**Application no: 21/02376/DISC**

**Location: E P Barrus Ltd, Launton Road, Bicester, OX26 4UR**

## **Lead Local Flood Authority**

Objection to discharge condition 6.

Drawn By:	RS	Client	Markbank Construction Ltd.
Chkd By:	WRA	Project	Proposed Redevelopment, Morley Site, Arkwright Road, Bicester
Scale @A3:	1:500	Title	Impermeable Area Plan
Date:	08.07.2021		
Status:	TENDER		
Project No.:	23200	Drawing No:	E13
		Rev:	B

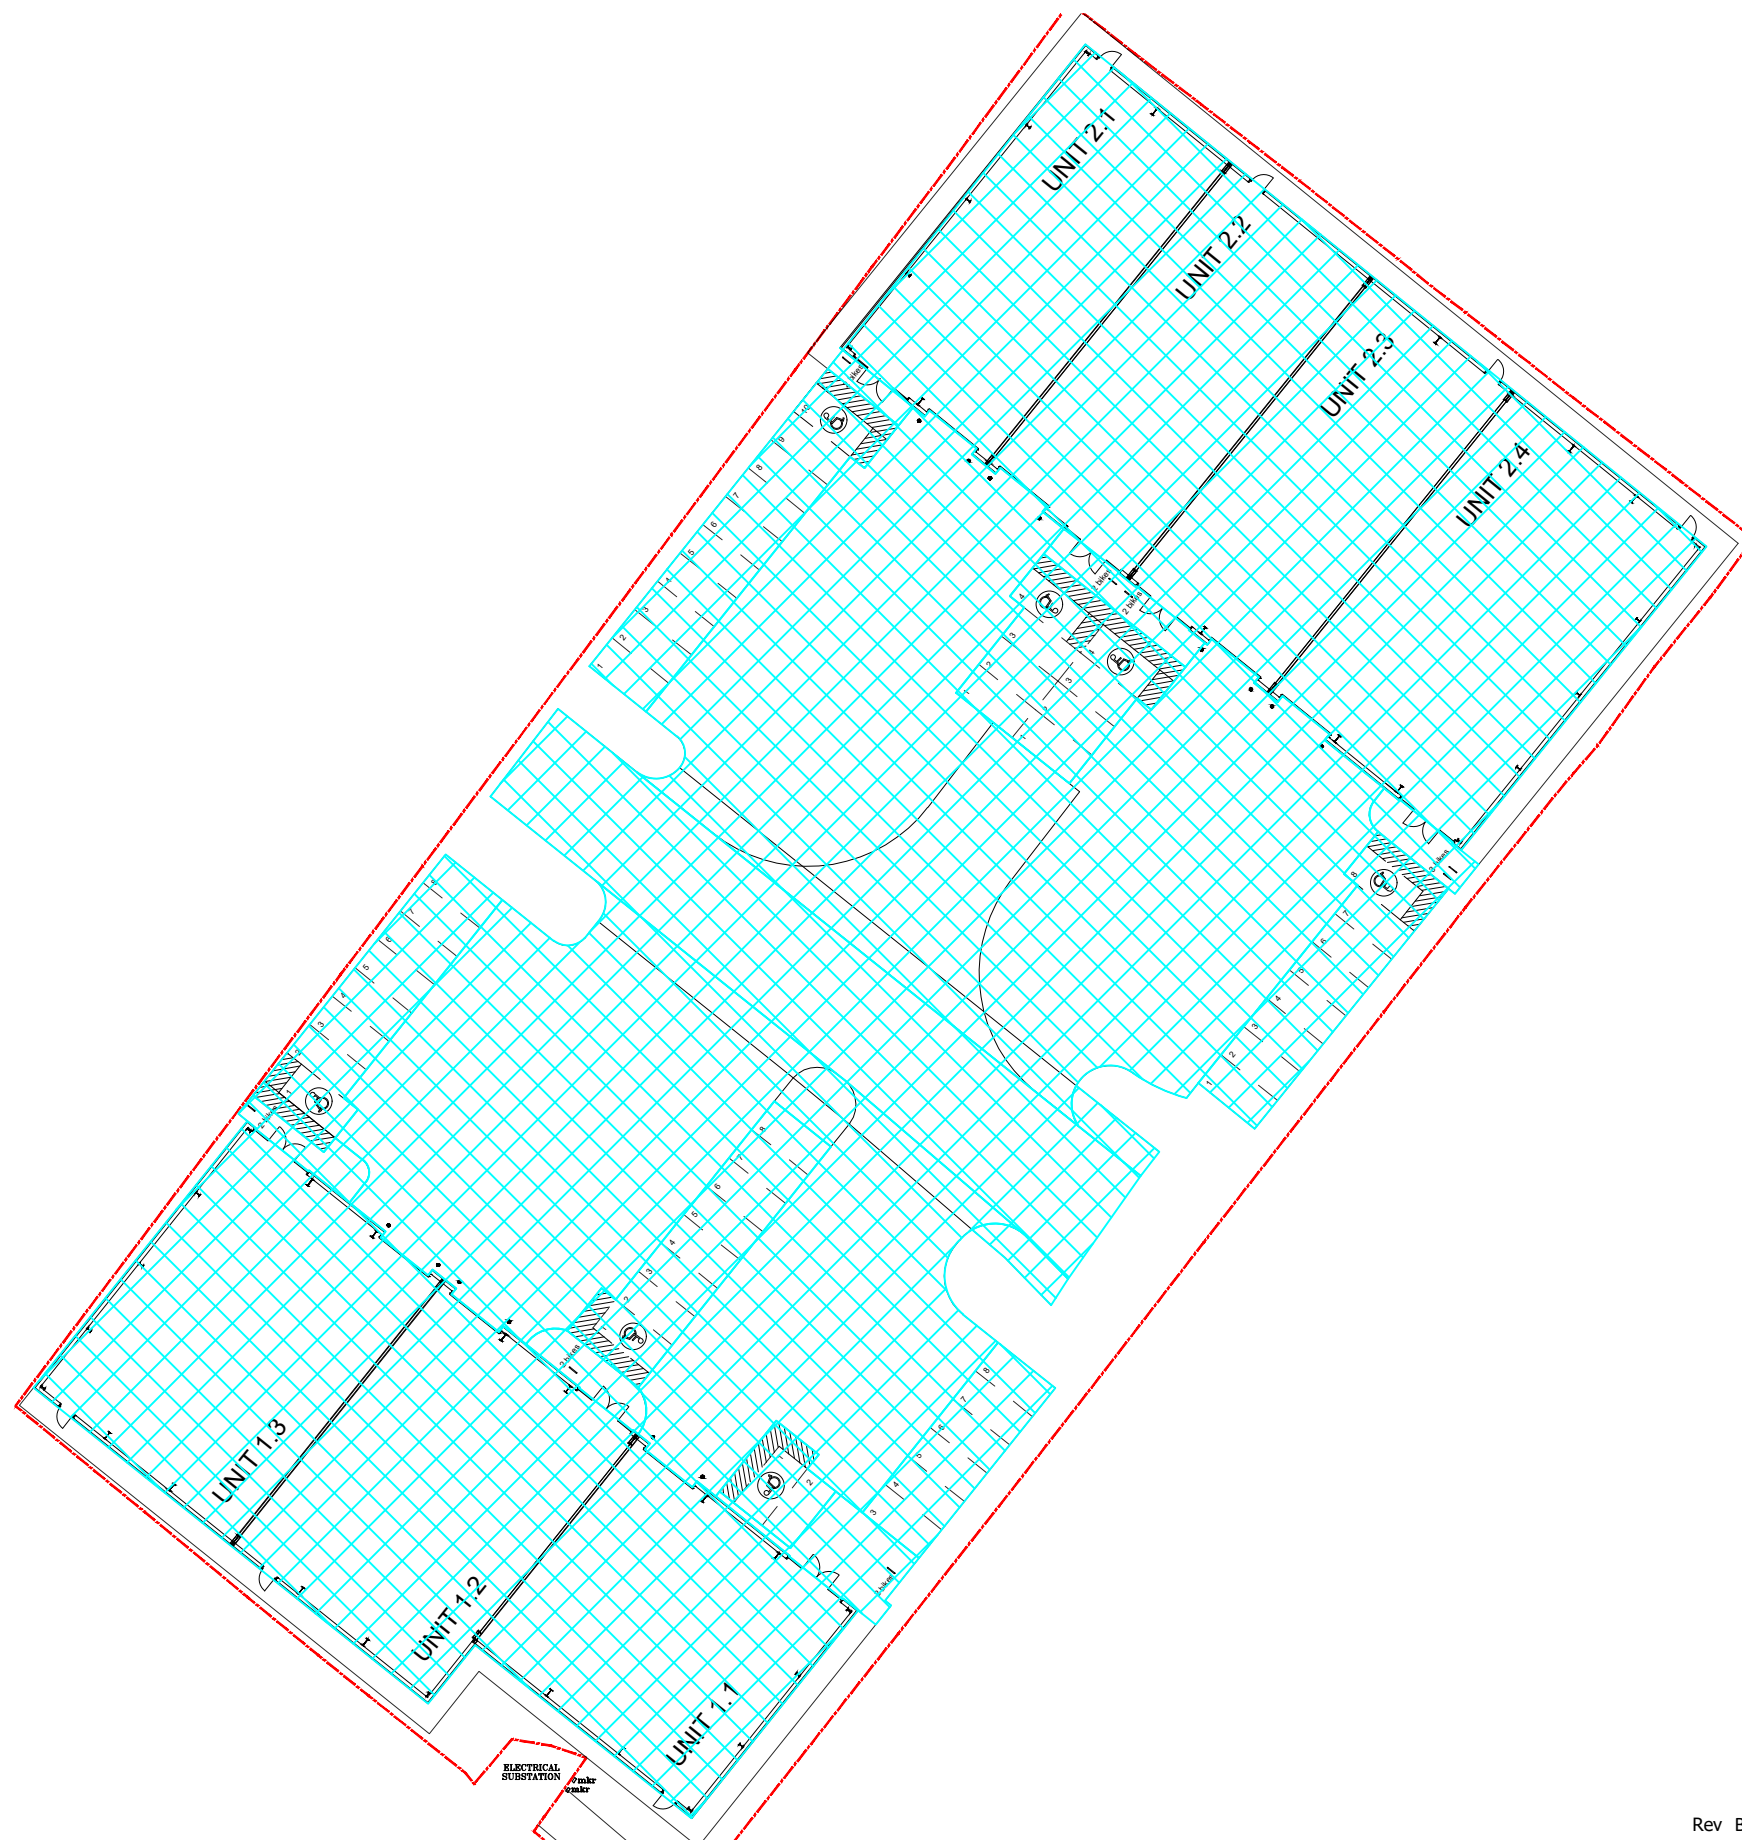
Calculations to be provided for brownfield run off rate. Brownfield site should match the greenfield run off rate, should this not be feasible then restrictions to brownfield rate with betterment is acceptable. Therefore please clarify why the drainage strategy does not follow the greenfield discharge rate.

<table><tr><td>Drawn By:</td><td>RS</td><td>Client:</td><td>Markbank Construction Ltd</td></tr><tr><td>Scale @ A0:</td><td>1:200</td><td>Title:</td><td>Proposed Drainage Layout</td></tr></table>

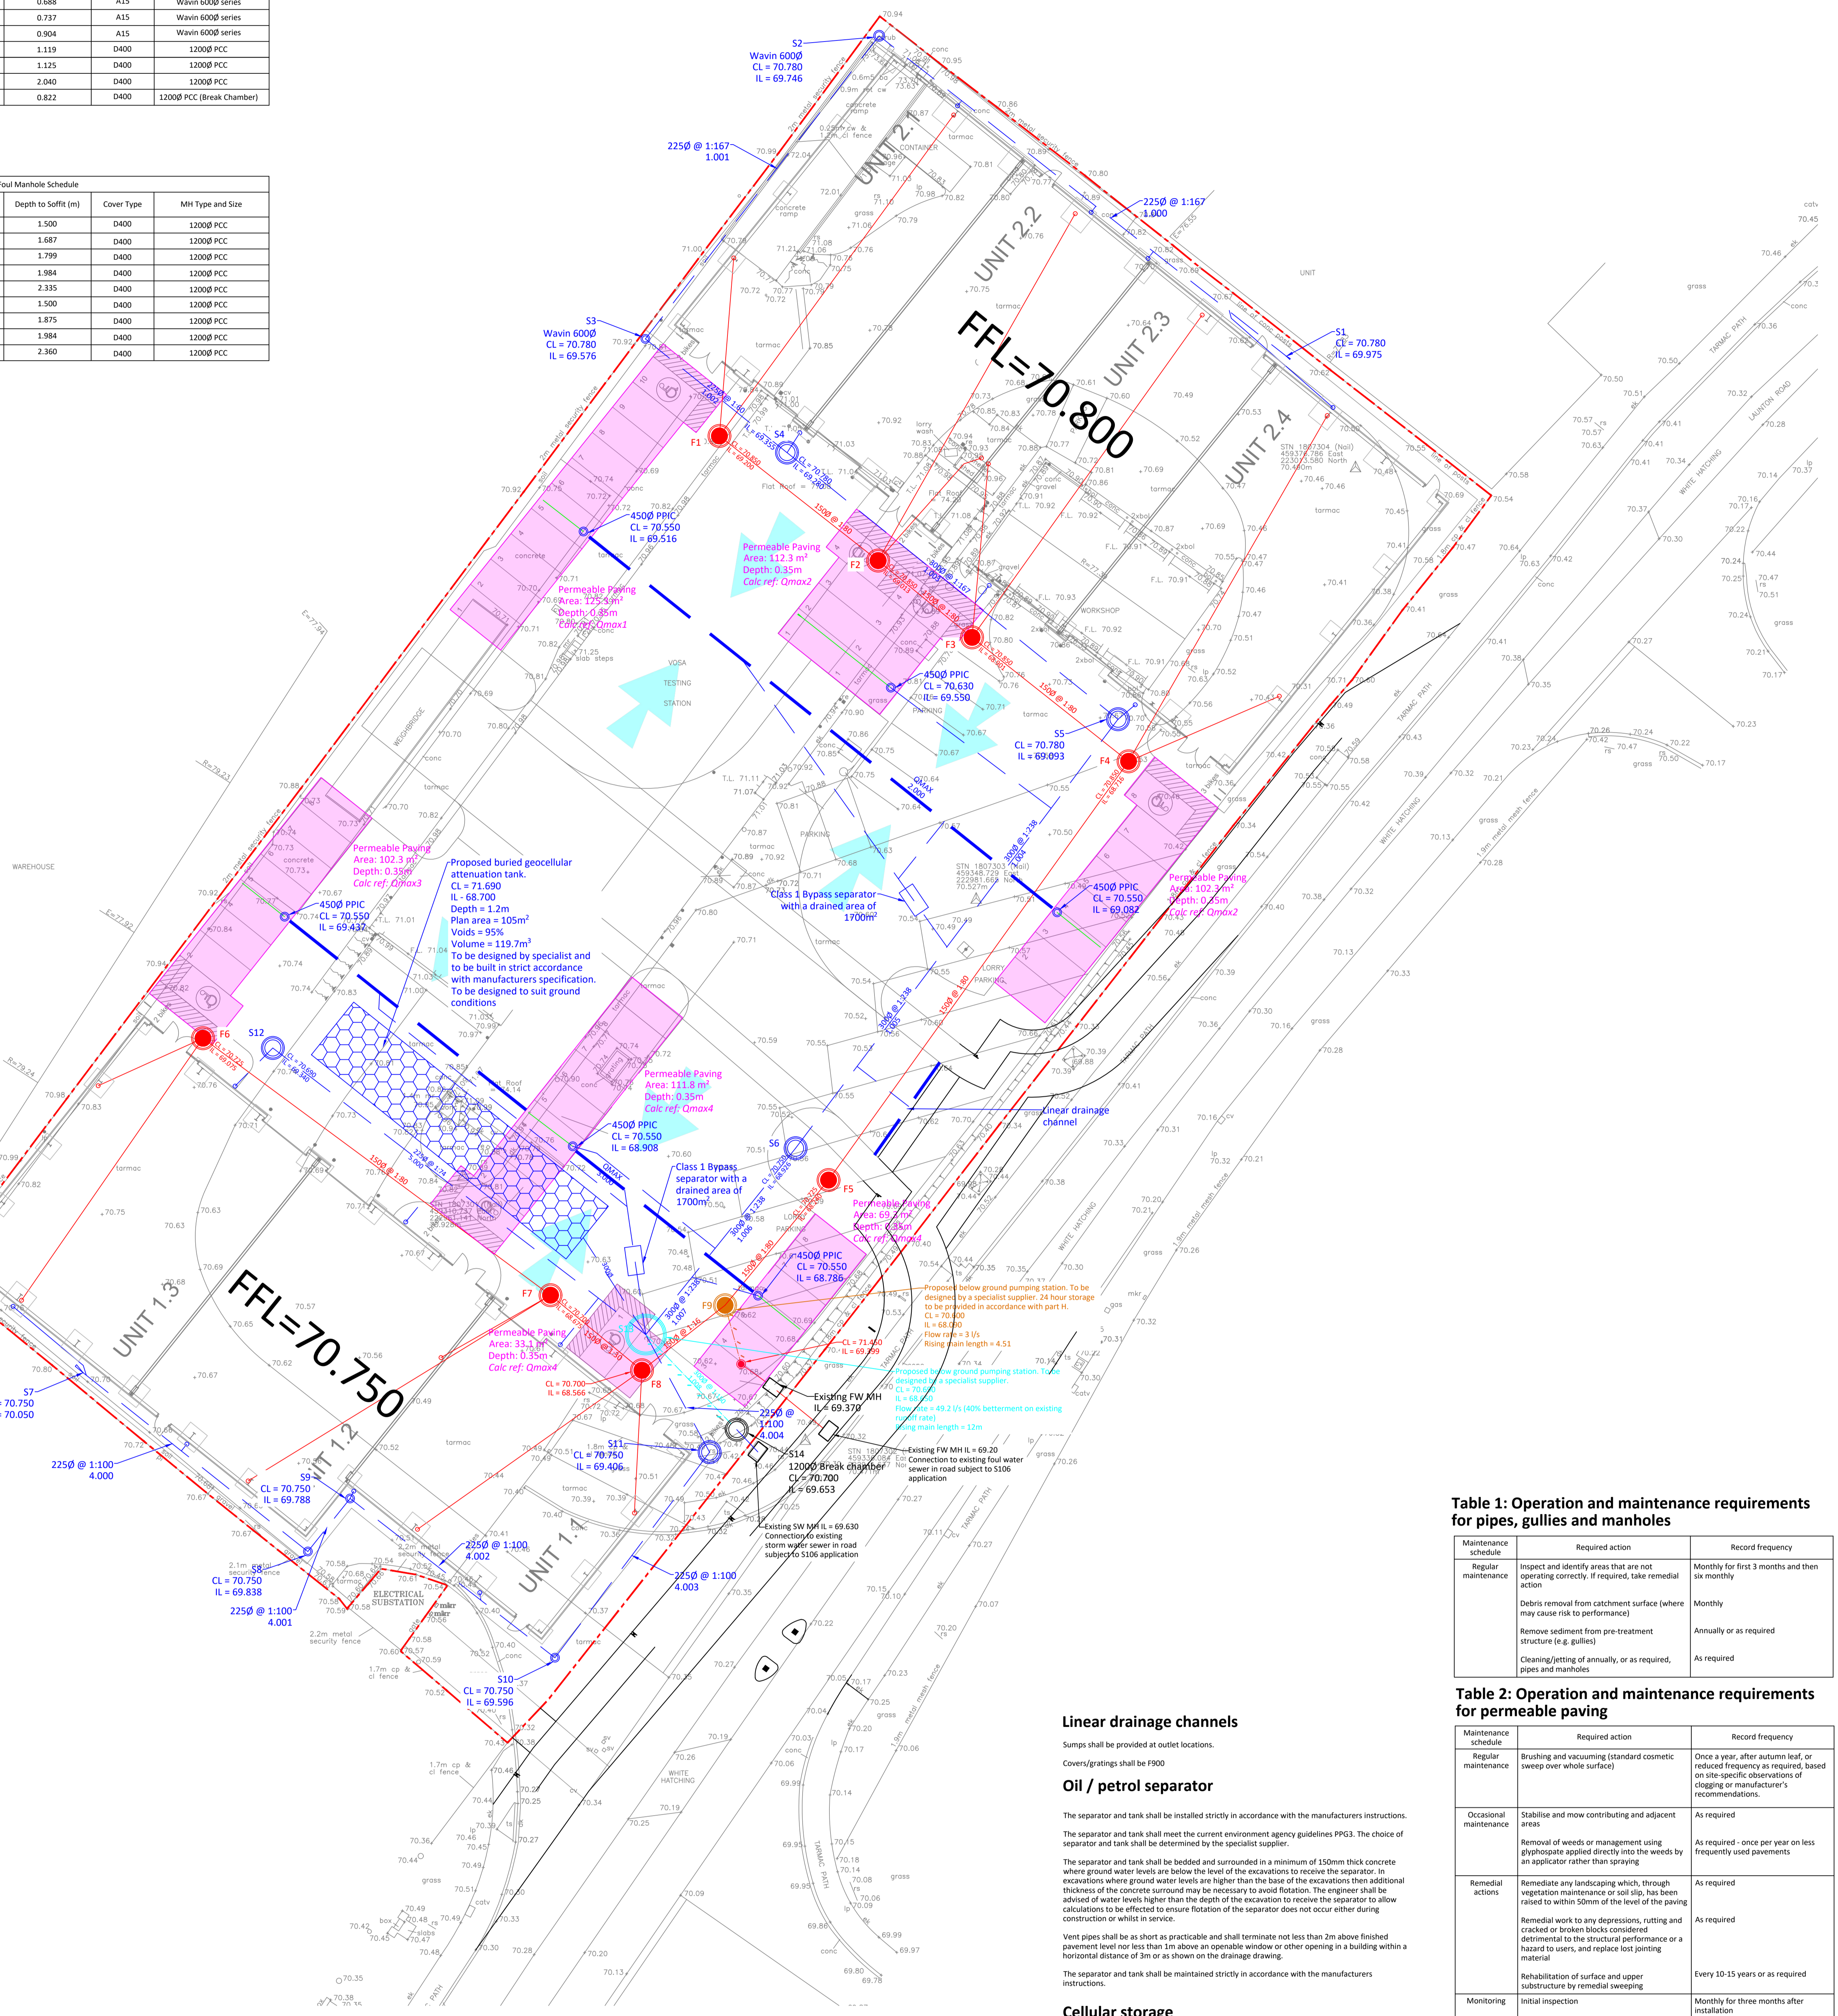
Drainage strategy drawing to be detailed. permeable paving area and sub base depth to be provided for each section of permeable paving.
